KITTITAS COUNTY

MEMORANDUM

TO: All Staff
FROM: Public Works Plan Review Team
DATE: July 26, 2022
SUBJECT: SX-22-00016 Longo

The Public Works Department has reviewed the Request for Shoreline Exemption Application.

National Flood Hazard Layer FIRMette

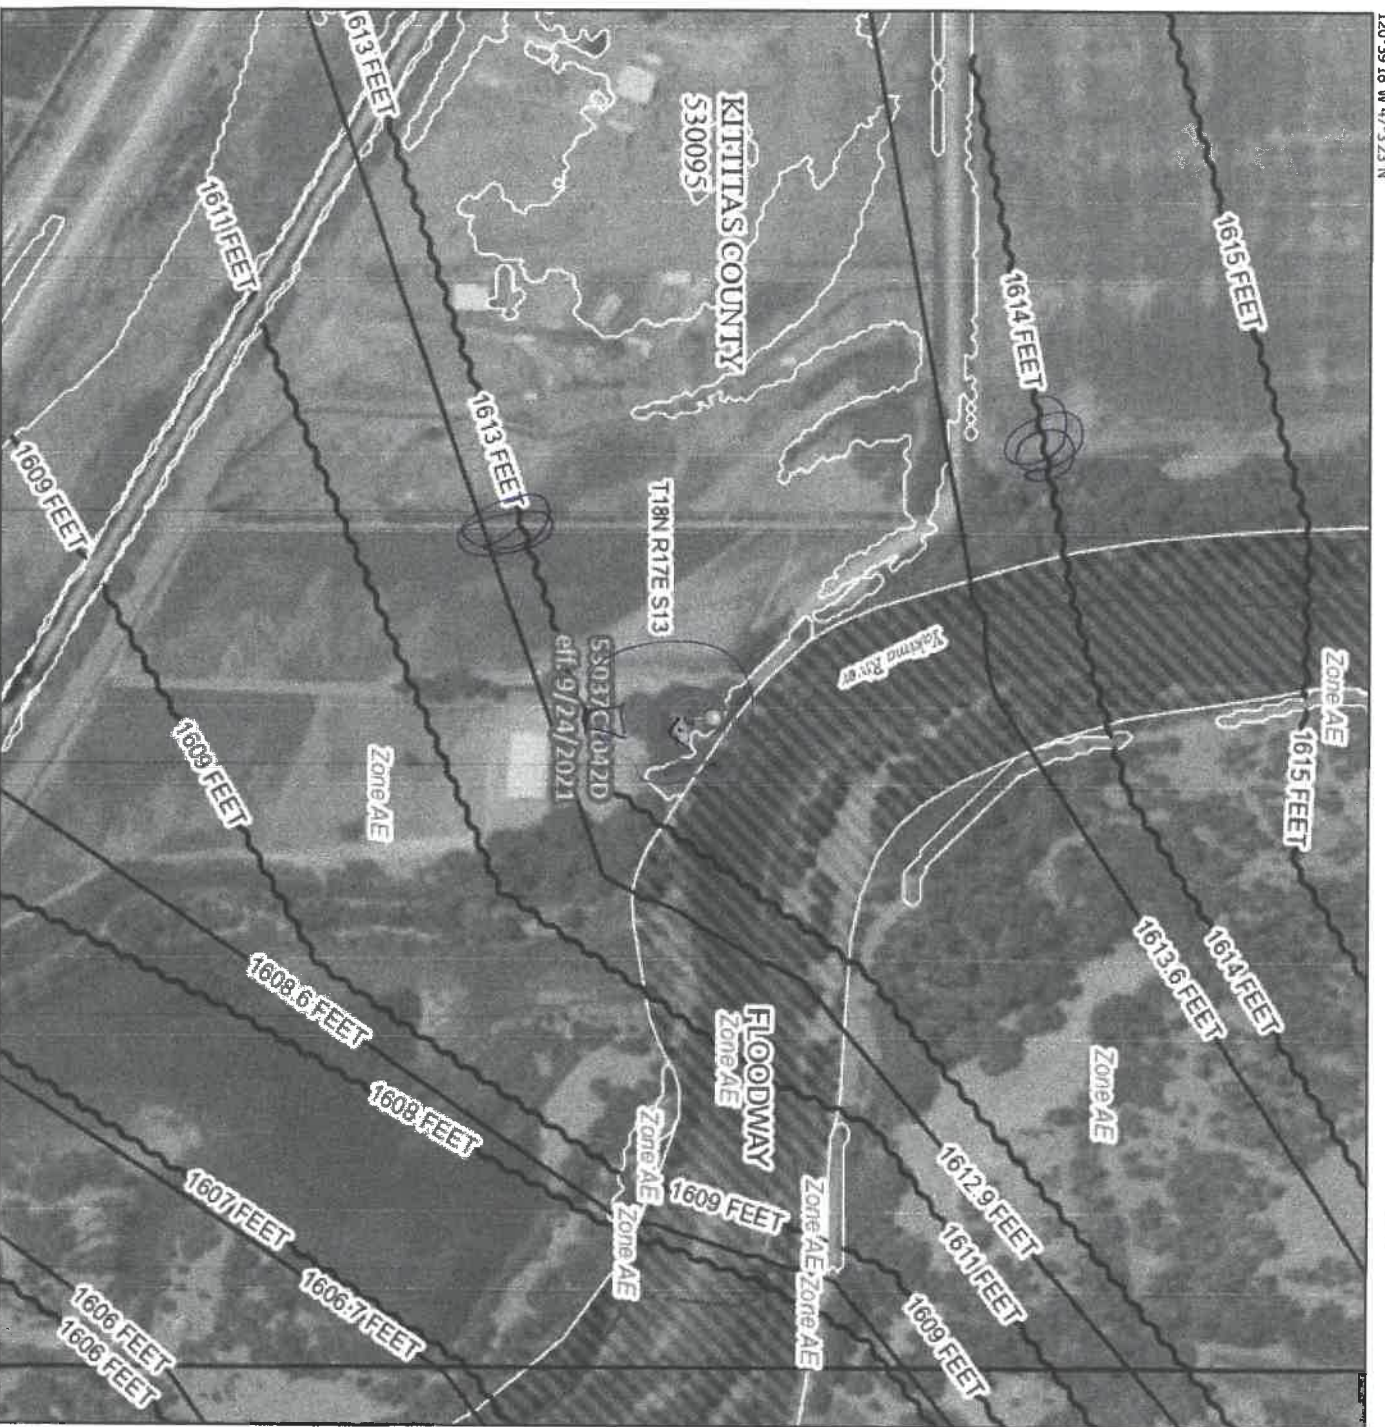
The proposed project is within the FEMA-identified special flood hazard area. A floodplain development permit is required, and the project will need to meet the standards identified in KCC 14.08. Based upon the information in the application, we understand the project to be a substantial improvement. Please note that encroachment into the FEMA designated floodway will not be allowed, and that the floodway boundary will need to be marked on site by a licensed surveyor. Available information indicates that the existing deck is encroaching into the floodway. If the field delineation of the floodway boundary verifies that any portion of the house, including the deck, extends into the floodway, it will need to be modified so that it no longer does so.

We also note that the existing house (and thus, the proposed house after the proposed modifications) is located very close to the Yakima River. Along this section of the river, there is a levee and series of rock barbs. Neither Kittitas County nor the Kittitas County Flood Control Zone District has any responsibility for the maintenance of the levee or rock barbs. We caution that the home site may be at risk of erosion even with the levee and barbs. Any future work to maintain the levee and barbs would require a floodplain development permits and would need to meet no-rise standards in order to be permitted. Given the stringent requirements of the no-rise standards, it should not be assumed that the placement of additional fill for the levee or berm, or modifications or repairs to these structures, would be feasible.
